Application Reference: 2025/0468

Site Address: 4 Fox Holes Grove, Crow Edge, Sheffield, S36 4HN

This application seeks full planning permission for a single storey rear extension to dwelling.

Drawing Title: Ground & Elevations - PROPOSED

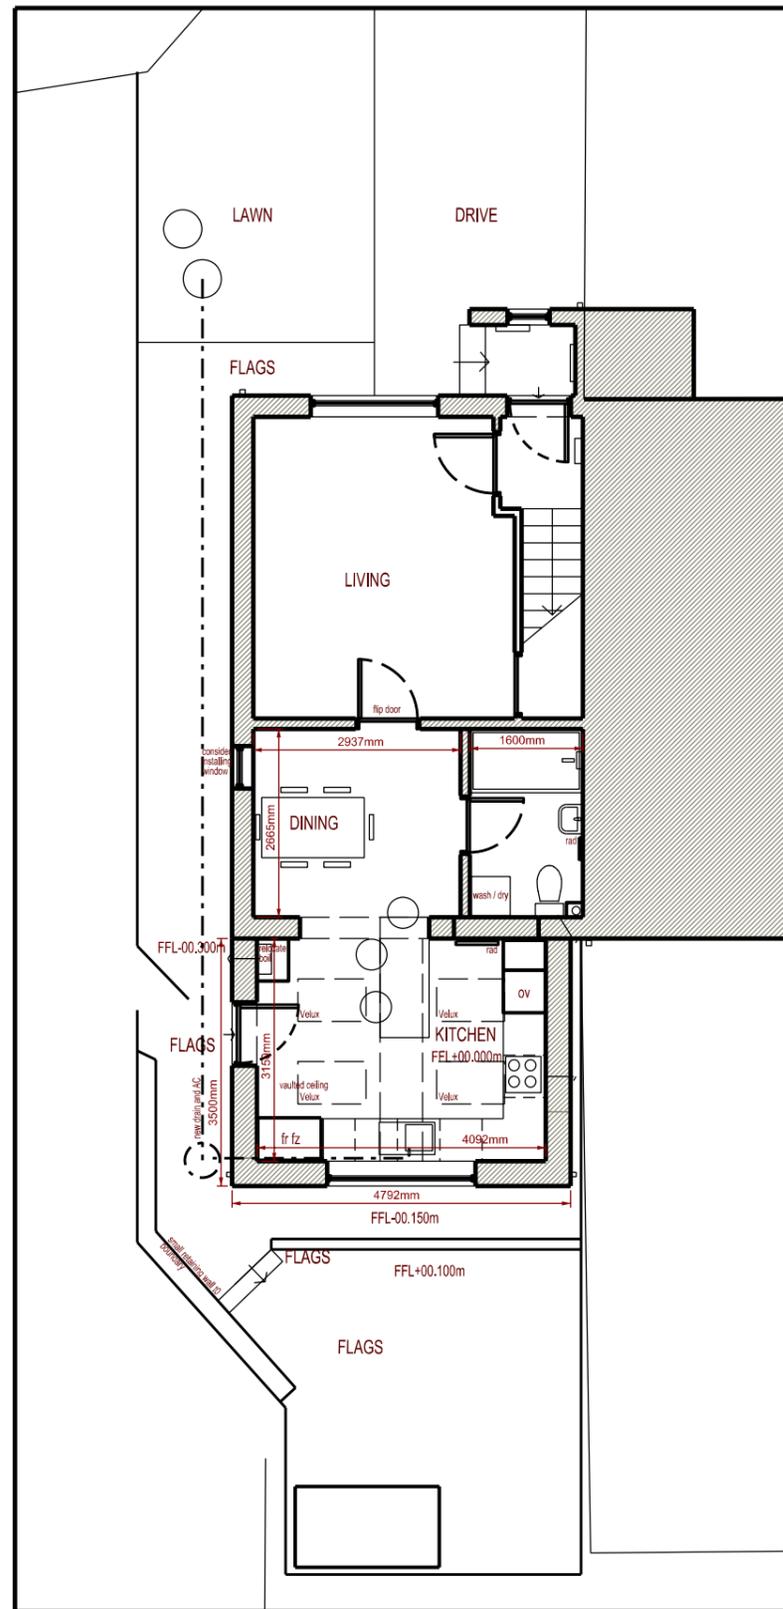
The property is located on Fox Holes Grove amongst dwellings of a similar design. The property is an end terraced dwelling with the rear elevation forming part of the surrounding street scene therefore the design and scale of the proposal needs to be closely assessed. The rear extension will be in stone to match the existing dwelling. SPD: House Extensions indicates that the roof style and pitch should match the existing, particularly when the extension will be prominent within the street scene. The application proposes a pitched roof the matches the existing property. The original proposal was deemed too large and was not in line with planning policy, however, the projection was reduced to 3.5m, therefore in this instance the proposal is acceptable.

The proposal is to erect a single storey rear extension designed with a pitched roof in matching materials. The proposal will project to the rear by 3.5m, measure 4.79m across, 2.42m to the eaves, 3.55m to the ridge. The extension will provide a kitchen extension with roof lights on both elevations.

Drawing Title: Ground & Elevations - PROPOSED

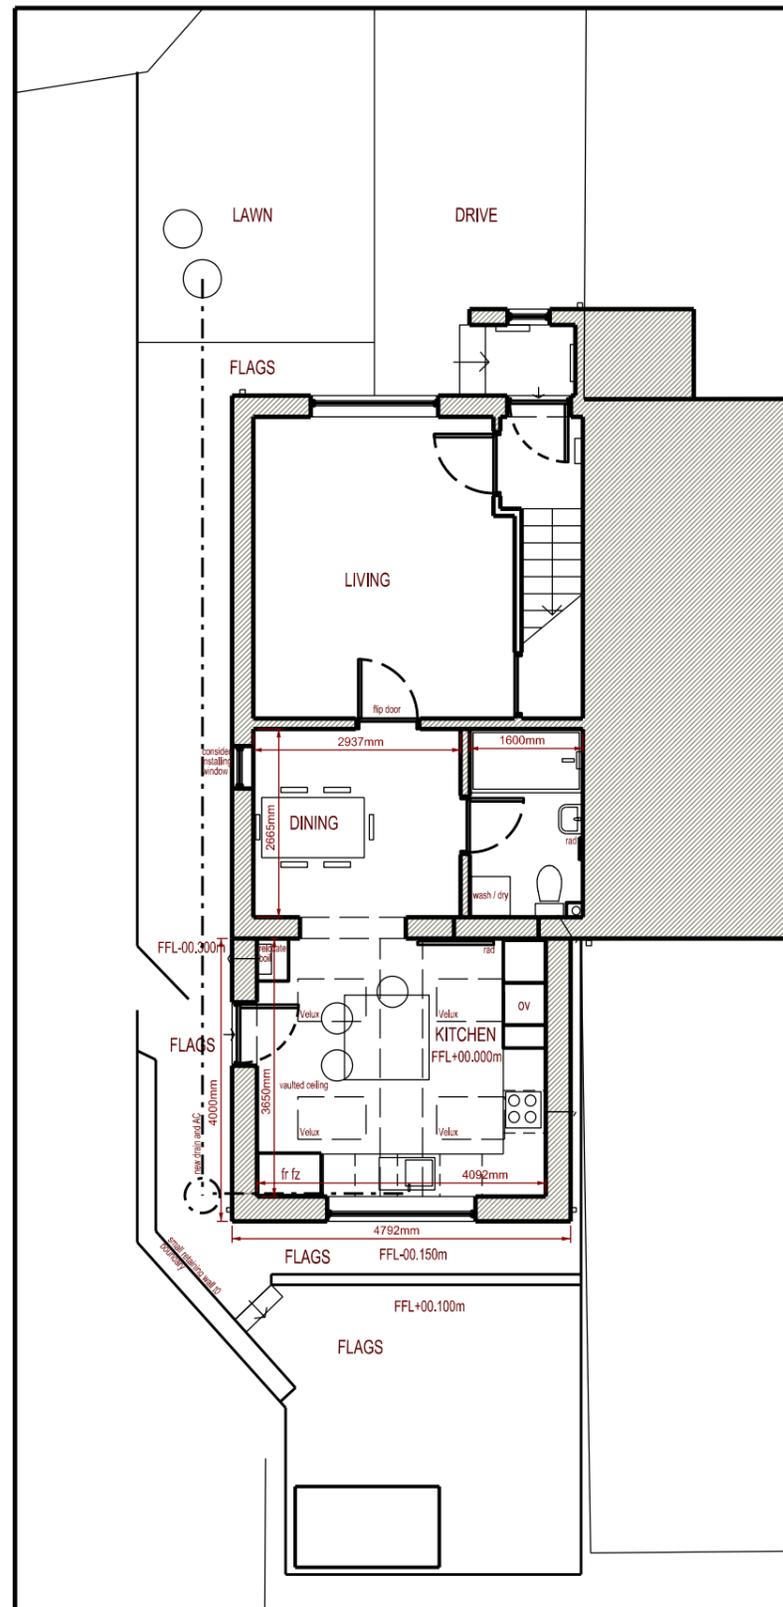
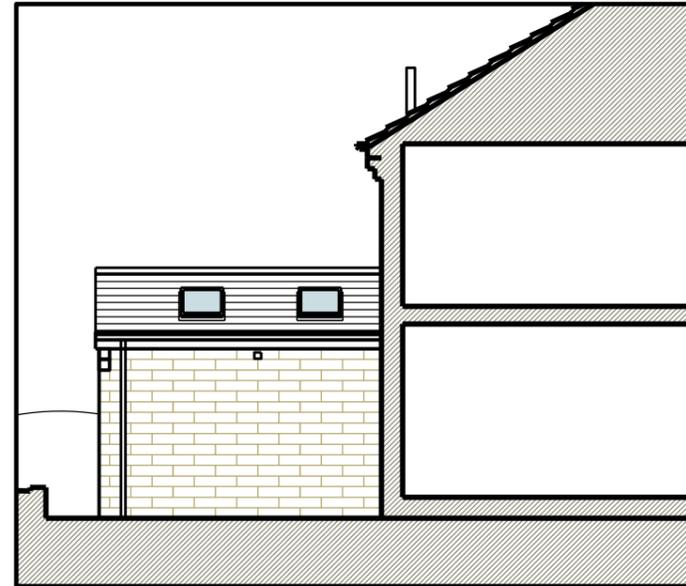
SPD: House Extensions indicates that extensions to the rear of terraced dwellings should not exceed 3.5m to protect residential amenity. It is noted that the adjoining property at the far end of the terraced row has an existing single storey rear extension at a much larger scale than the proposed. This was agreed through a prior notification, with no objections therefore was not assessed against the Council's planning policy. The proposed extension has been reduced to 3.5m in projection with eaves less than 2.5m in height which meets the criteria set within SPD: House Extensions.
